Rezoning Transportation Analysis

Petition Number: 2024-143

Date	Description
1/22/25	First Review (CJM)
2/19/25	Second Review (CJM)
9/24/25	Third Review (CJM)
10/23/25	Fourth Review (CJM)

**RZ-1**

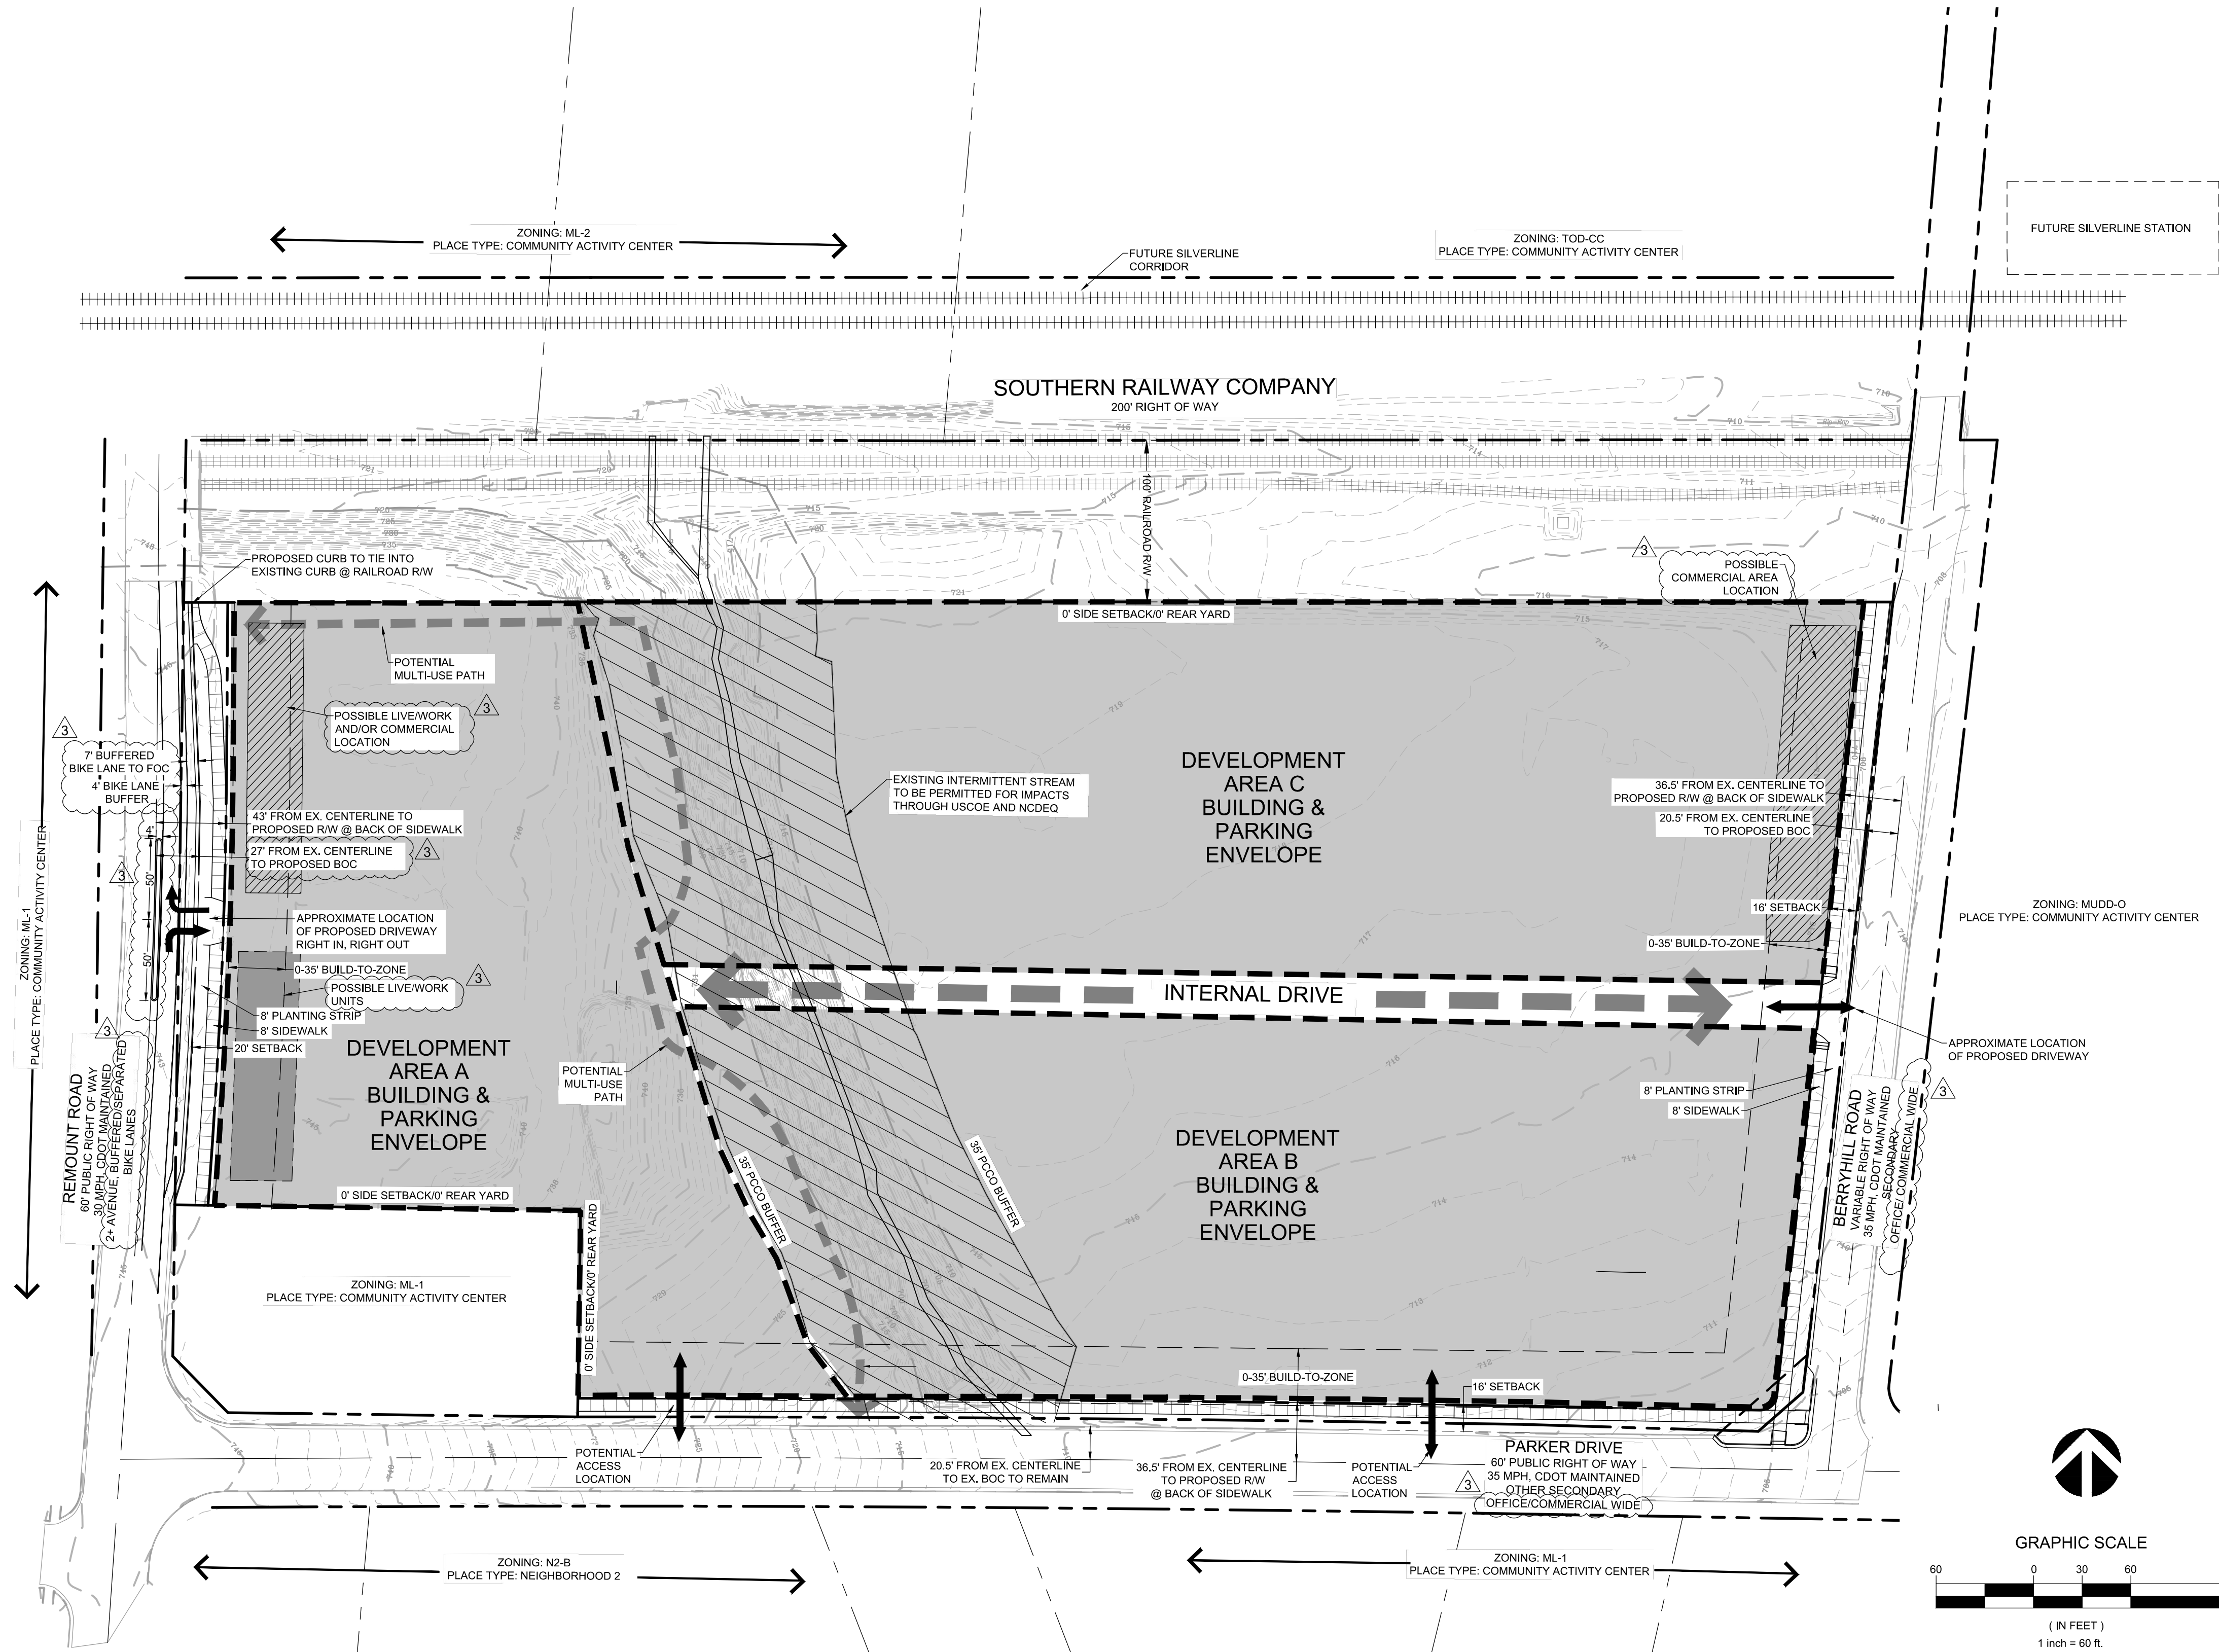
- a. **Remount Road:** Location of future back of curb and gutter to be installed 27' from centerline.

7. **New Comment 9.24.25:** Revise site plan to add buffered/separated bike lanes to Road Label and show, label and dimension the buffered/separated bike lane along frontage on the site plan. Add a conditional note committing to installing this improvement.

Clarifying Comment 10.23.25: Dimension bike lane as 5' wide (gutter pan not included in width). For cross section dimensions revise bike lane buffer to read "bike lane buffer width to vary, 3' minimum". The exact width and transitions of the buffered bike lane will be coordinated during permitting.

8. **Outstanding Comment from 9.24.25:** Revise site plan to dimension width of median along Remount Road to 4' minimum and be installed 50' past the driveway in both directions. Add a conditional note to note this commitment.

Clarifying Comment 10.23.25: 50' dimension is from curb return/edge of the driveway (not the centerline). Update median to show it is extended a minimum of 50-feet past the curb return/edge of the driveway in both directions.
